# Oxford Technology Park Langford Lane Kidlington

21/02278/F

**Proposal:** Development within Use Classes E (g) (i), and/or (ii), and/or (iii), and/or B2

# SUMMARY OF RECOMMENDATION: GRANT PERMISSION SUBJECT TO CONDITIONS

content : BUILDING 4A & 4B PROPOSED CYCLE LOCATIONS

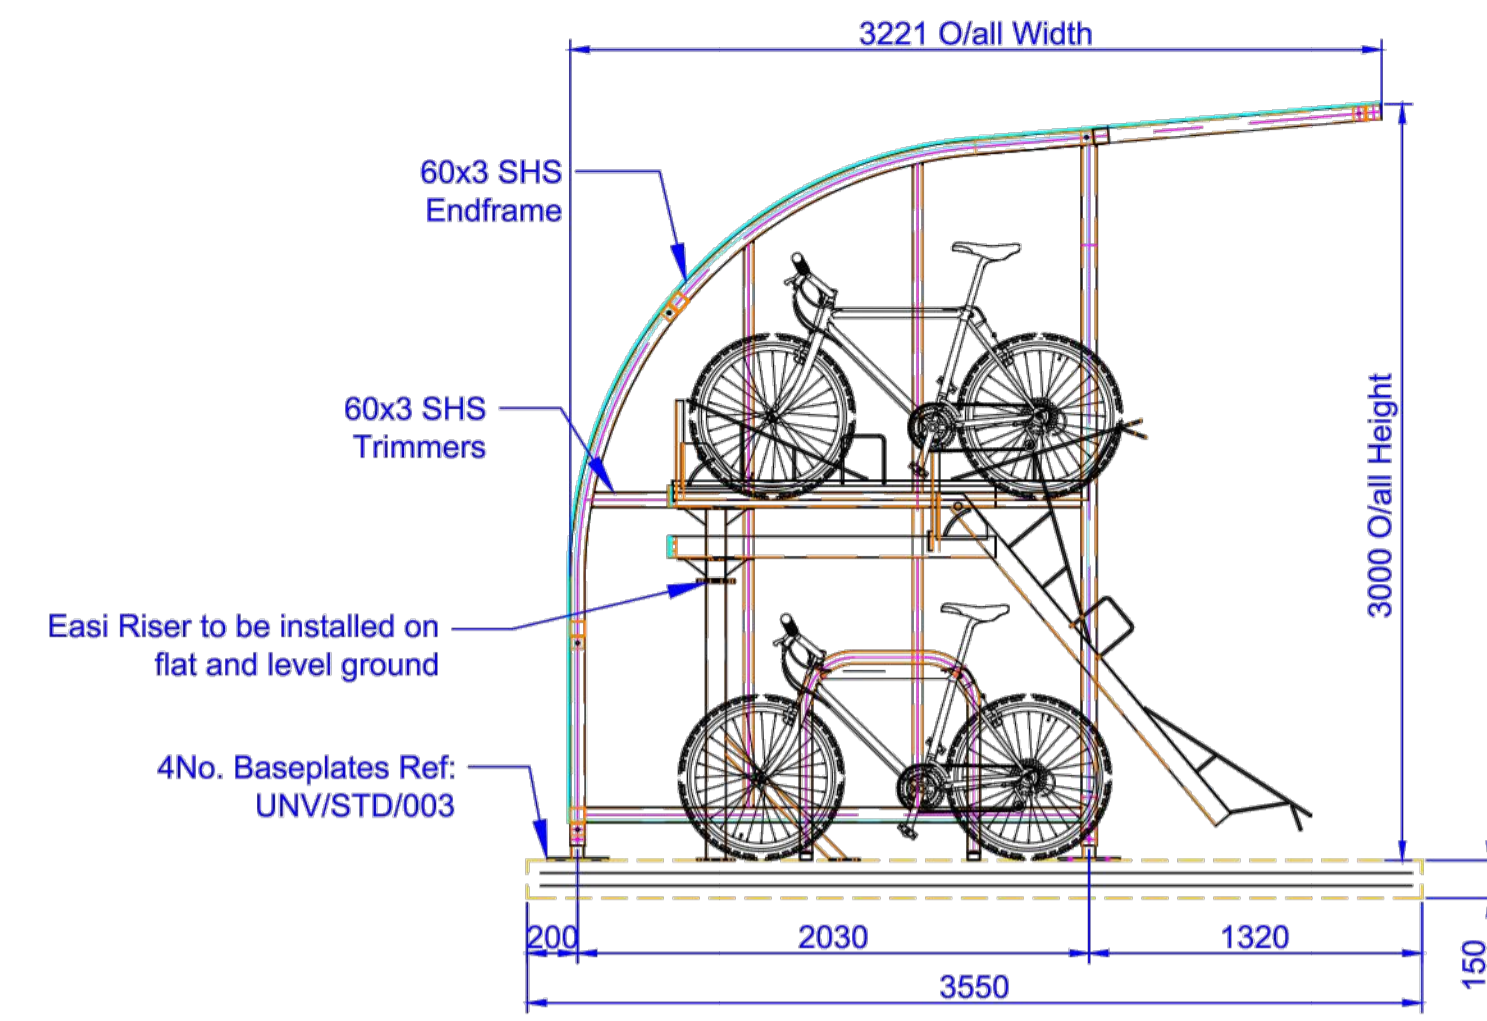
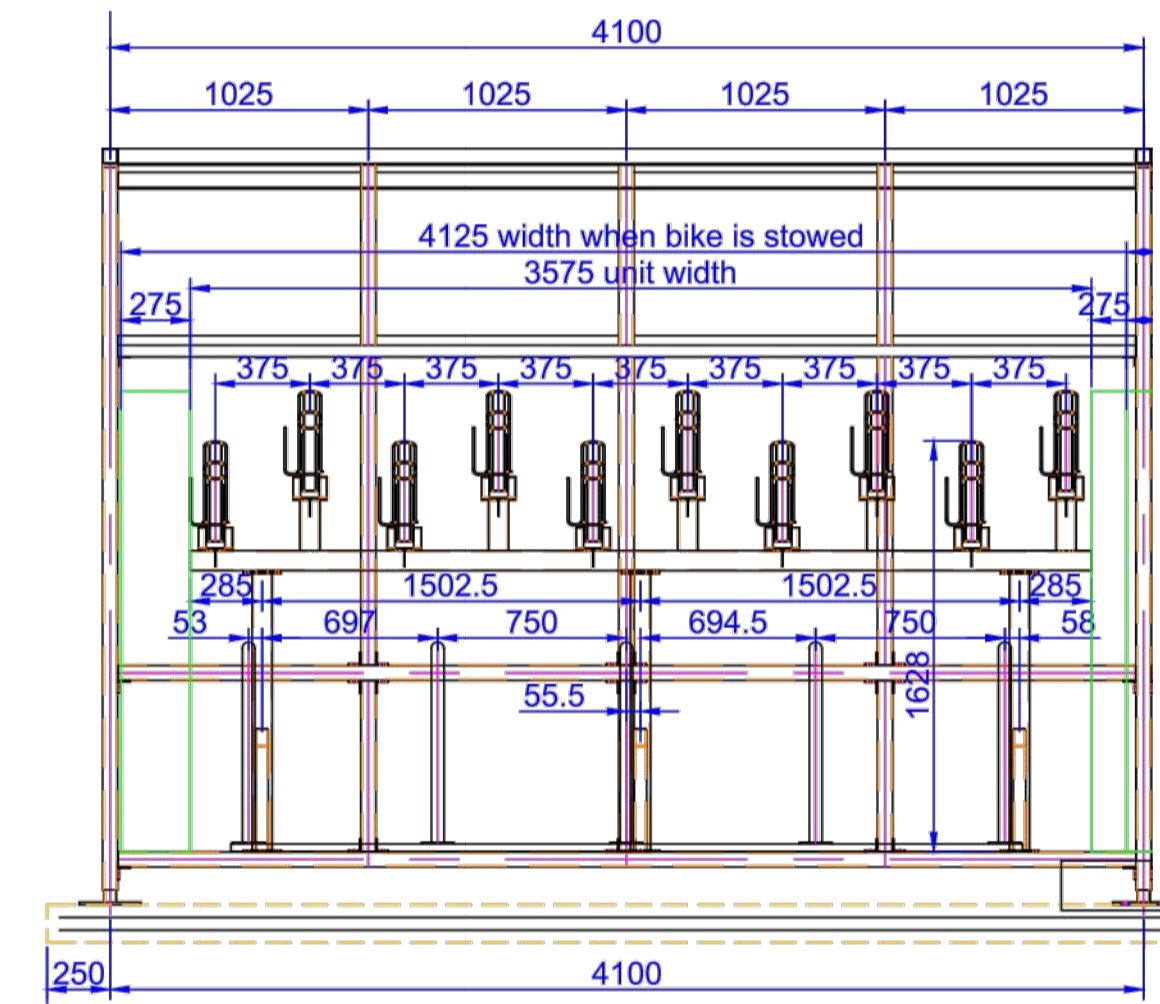
- 2.11 The proposed development includes provision for 4 shelters with two on the site frontage and two at the rear of the proposed units on the access road between Units 4a and 4b. Each accommodating 10 cycle stands in a stacking mechanism creating a total provision of 40 spaces. This provision is consistent with the provision provided elsewhere on the Park and maximises the use of the site. Further the proposals would be consistent with national guidance in LTN 1/20. Whilst the County Council in their updated guidance would prefer Sheffield stands, taking account national guidance and the use of stacking systems on the development is considered acceptable and has been considered acceptable elsewhere.

- 2.12 The application plans also show two bin stores (one for each building) located to the rear boundary. These details are easily accessible to service the site and would be also accessible to bin and refuse vehicles.

- 2.13 As such it is considered that the submitted details are considered to be acceptable and in accordance with the aims and objectives of national guidance in LTN 1/20 and consistent with other implemented and approved neighbouring development.
